# Sizewell C

## Detailed review of the SZC Co. Public Consultation (11<sup>th</sup> June to 12<sup>th</sup> July 2021)

DRAWING TITLE:
SIZEWELL LINK ROAD
MOAT ROAD JUNCTION
PROPOSED GENERAL ARRANGEMENT

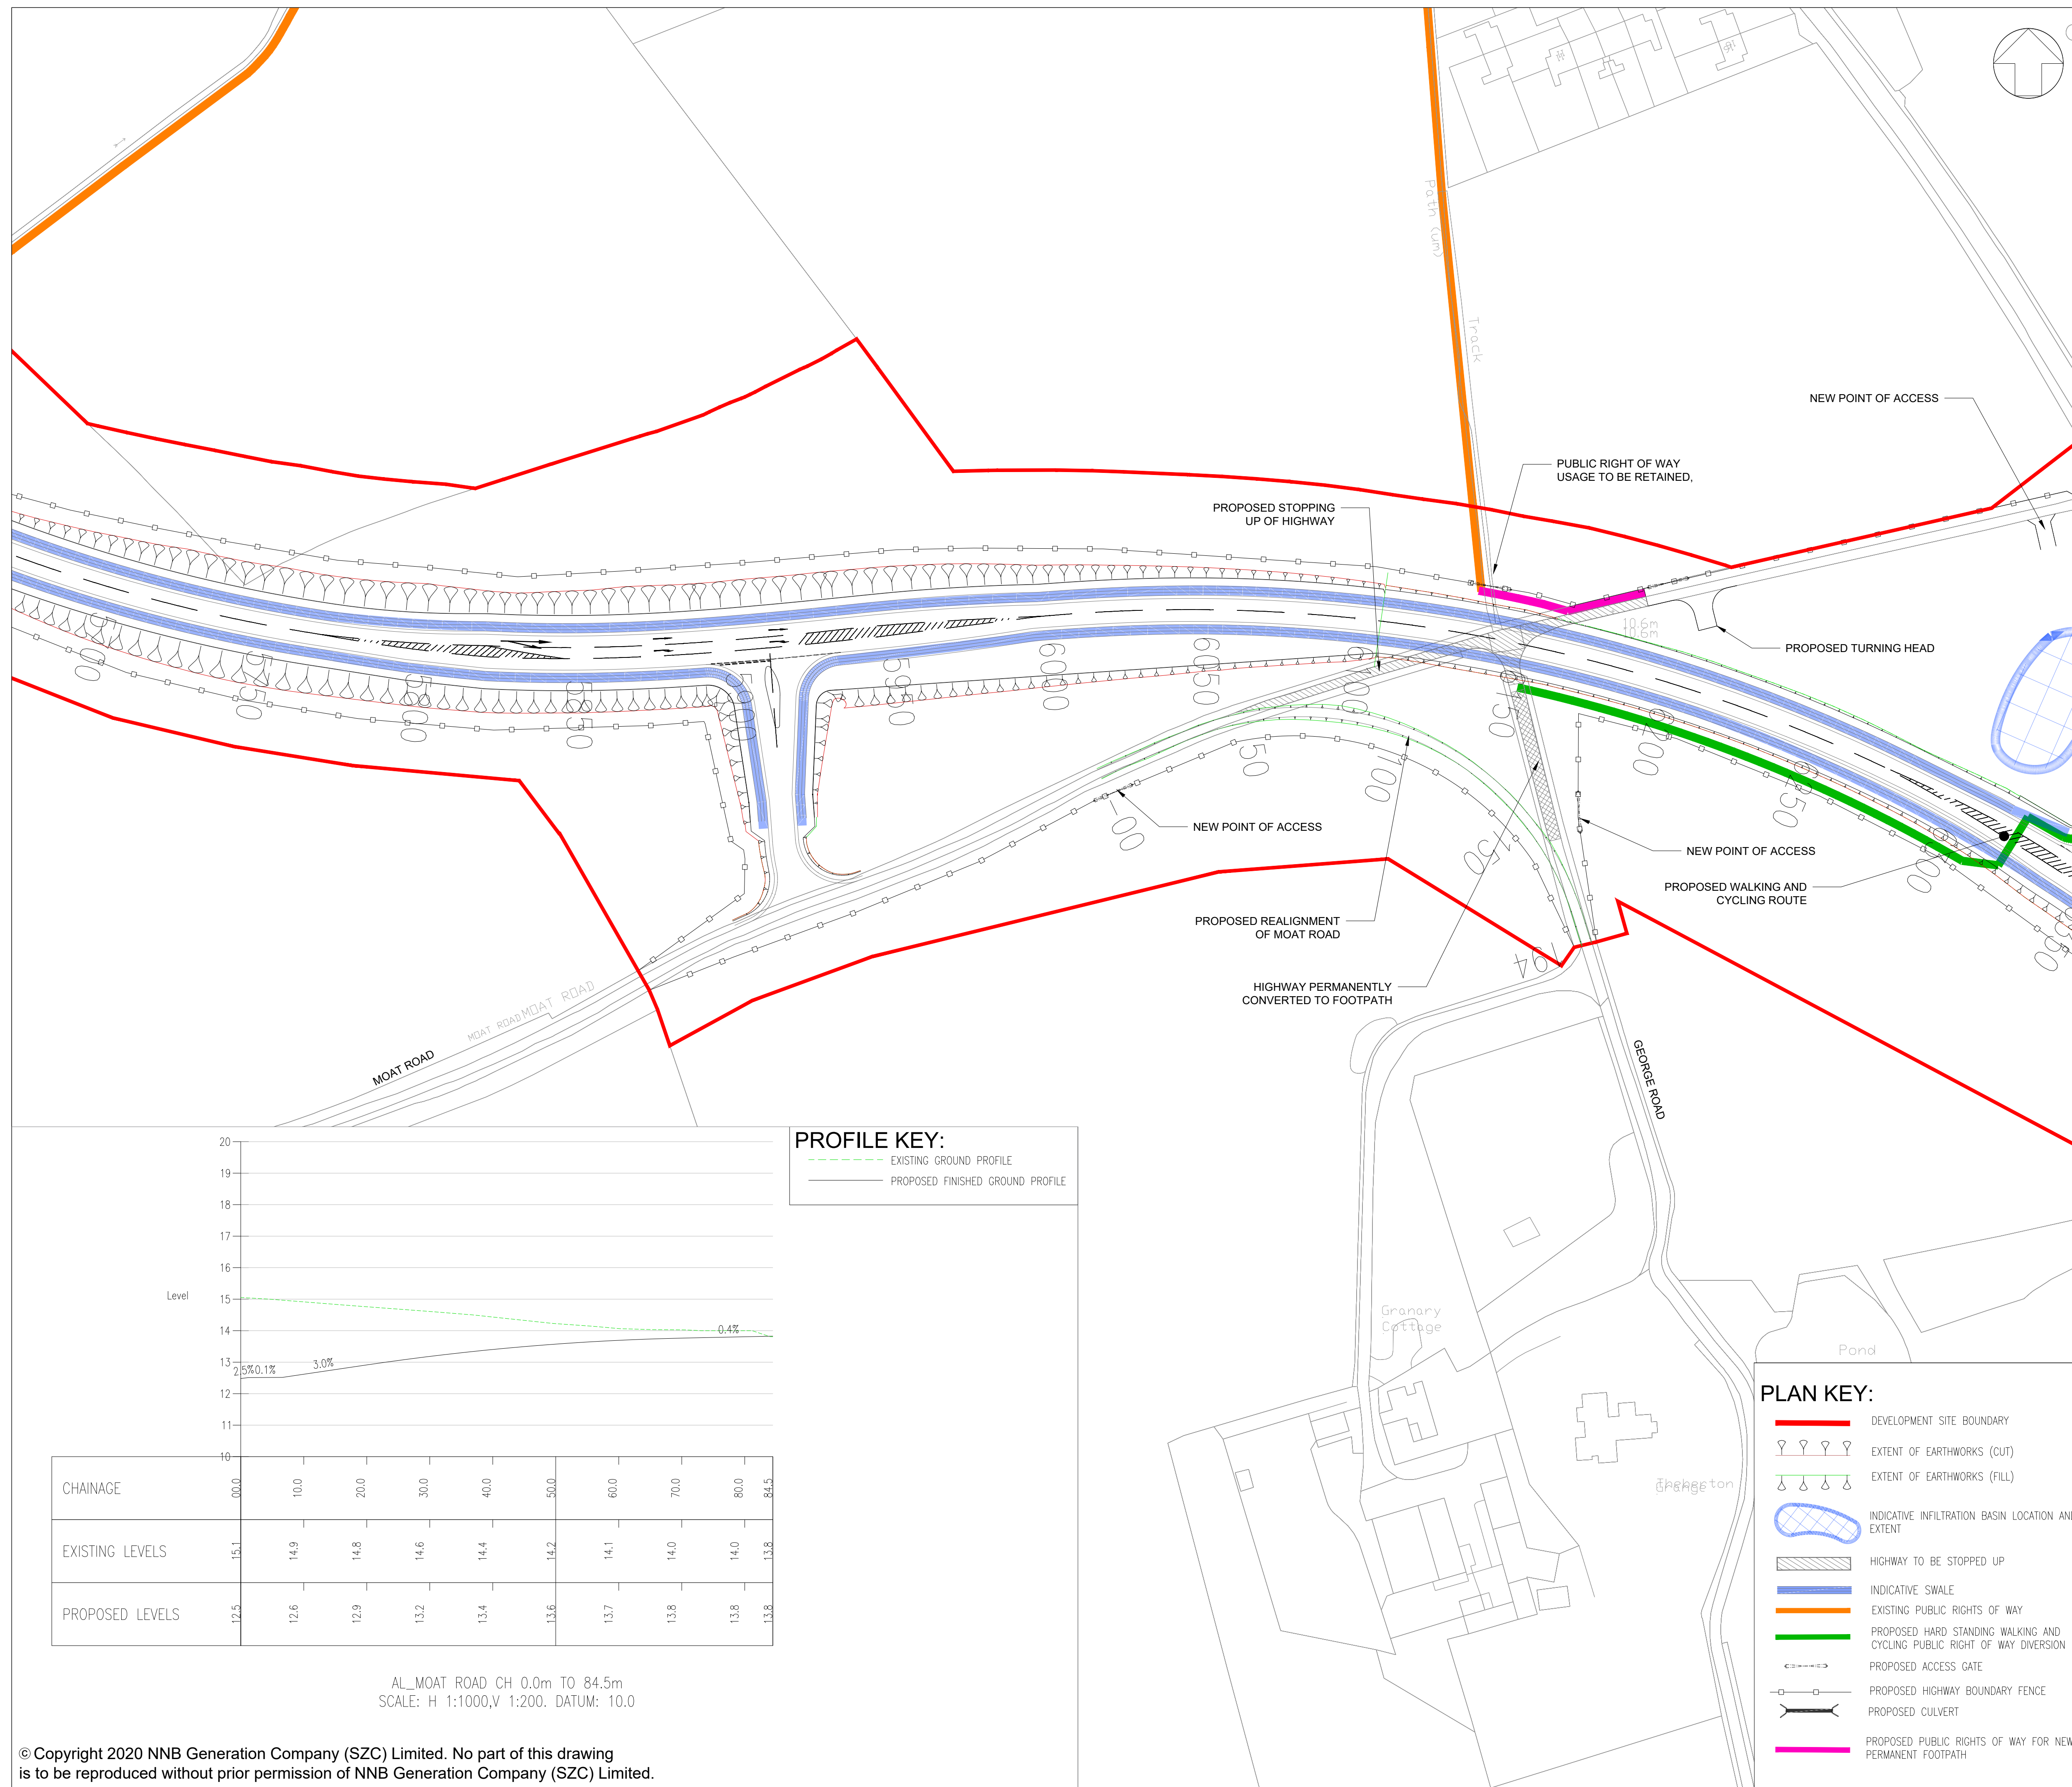
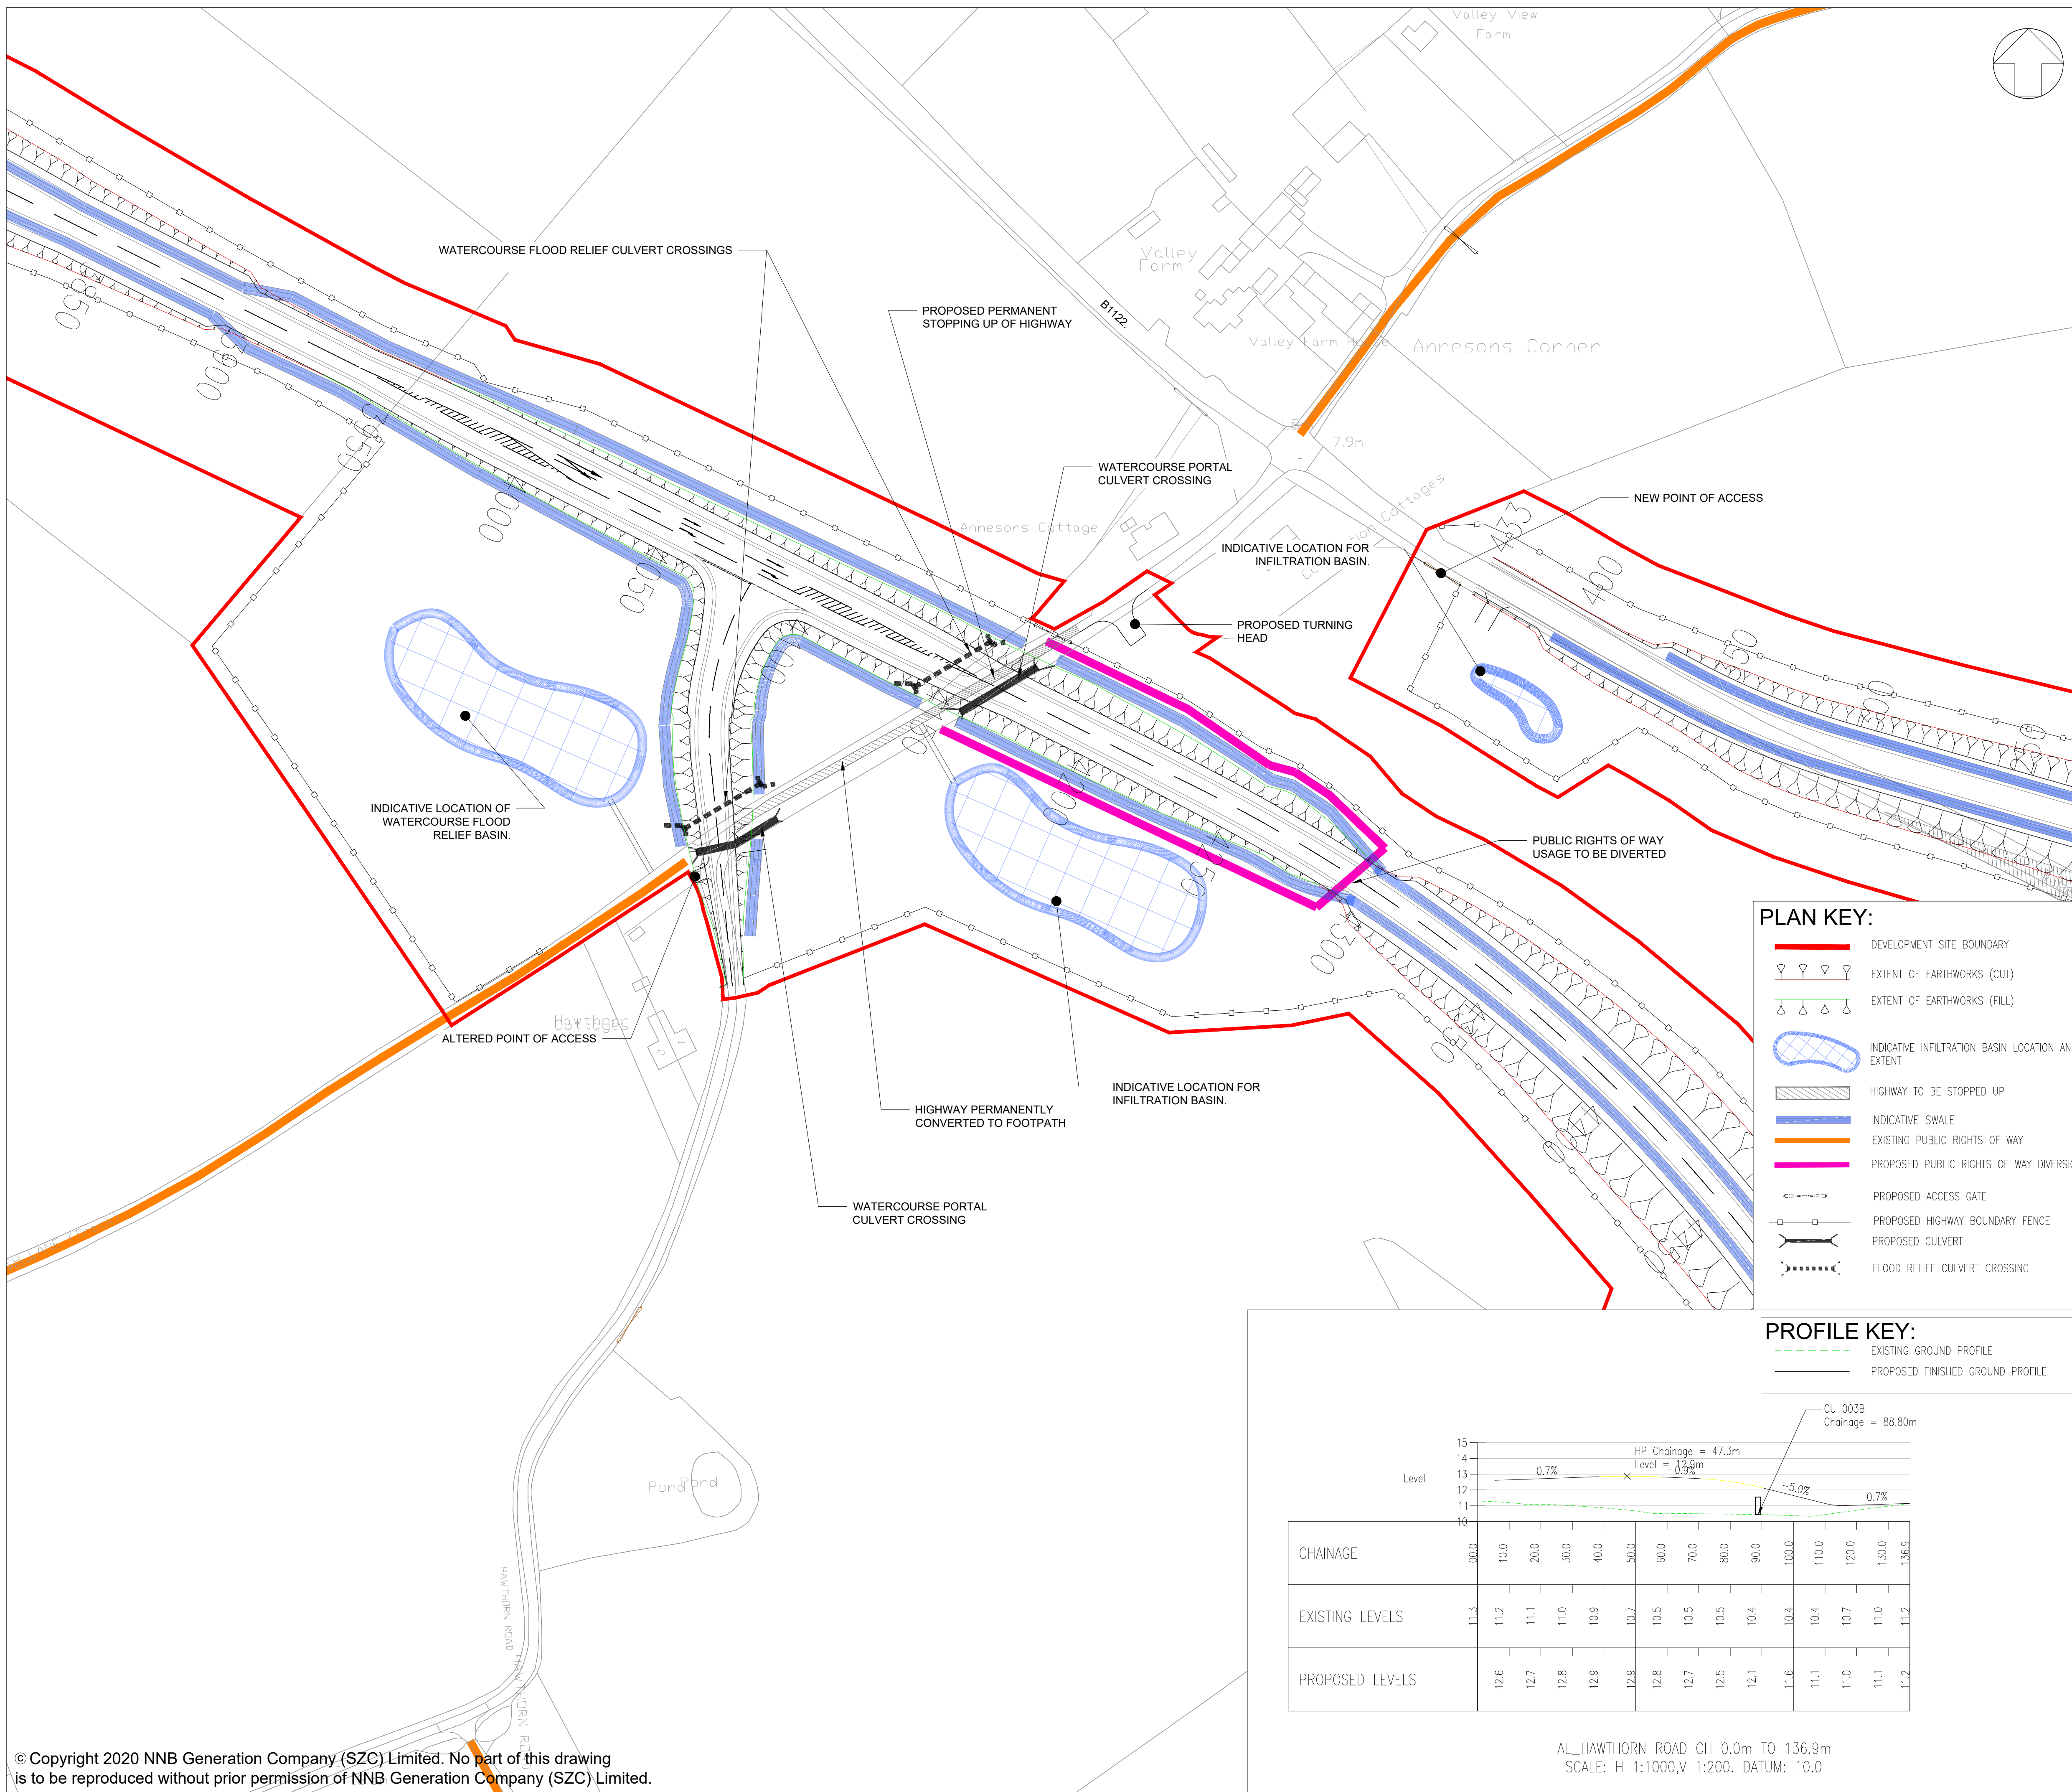
Moat Road being stopped up will cause loss of amenity/utility to Kelsale-cum-Carlton and to other Coastal Suffolk residents. Safeguards would be required as per 4.2.2.
